From: Simon Davis
Sent: 30 April 2018 14:42
To: Planning.Responses
Subject: FW: Land at Kings Close, Yapton - Y/21/18/DOC

Further drainage comments

Thank you for sending through the revised information. My comments are:

PROJECT
Standard Detail
High Storage Soakaway

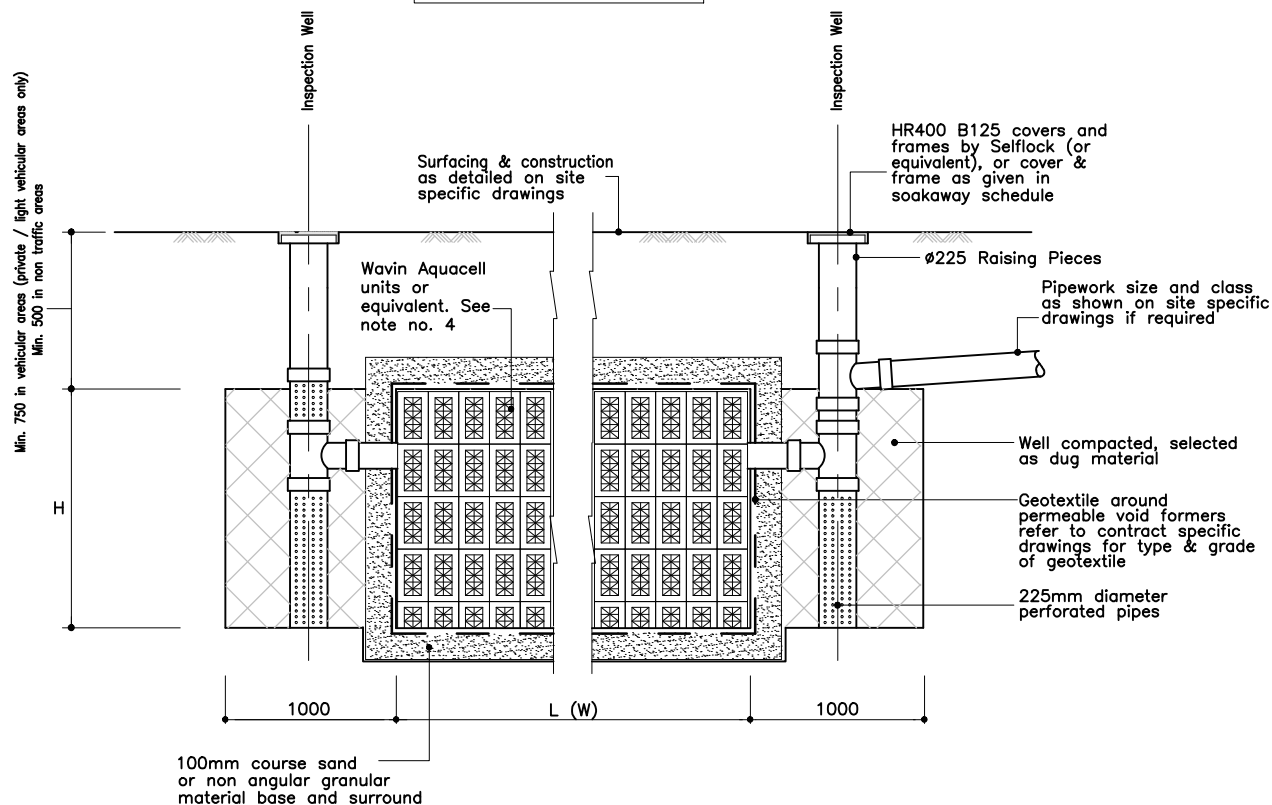
- Could you please provide a plan detailing the invert level and cover level of the soakaways, (I realise some details are given in the schedule tables), but I would like to see these on the plan.
- Step rungs need to be specified in manholes, please specify on detail drawings.
- The depth of the concrete specified at the bed of catchpit manholes needs to be increased to 225mm.
- Manhole covers need to be ductile iron, please specify on drawings.
- Please provide a plan showing exceedance flow routes.
- Can you please supply me with the cross sectional drawings through the proposed retaining wall.

1. SA-A has a maximum calculated water depth of 1.13m. However, on the general arrangement drawings the inverts are set too high for this. I.e. the soakaways are only 0.93m deep in some locations, and that is disregarding cover depth. At all locations the soakaways are too shallow. Please re-evaluate design.
2. SA-B has a maximum calculated water depth of 1.04m. However, plan depths (disregarding cover) are as shallow as 0.51m in some locations. At all locations the soakaways are too shallow. Please re-evaluate design.
3. SA-C has a maximum calculated water depth of 1.12m. However, plan depths (disregarding cover) is 0.59m. Please re-evaluate design.

5. Please provide construction details for soakaways, manholes and silt traps.
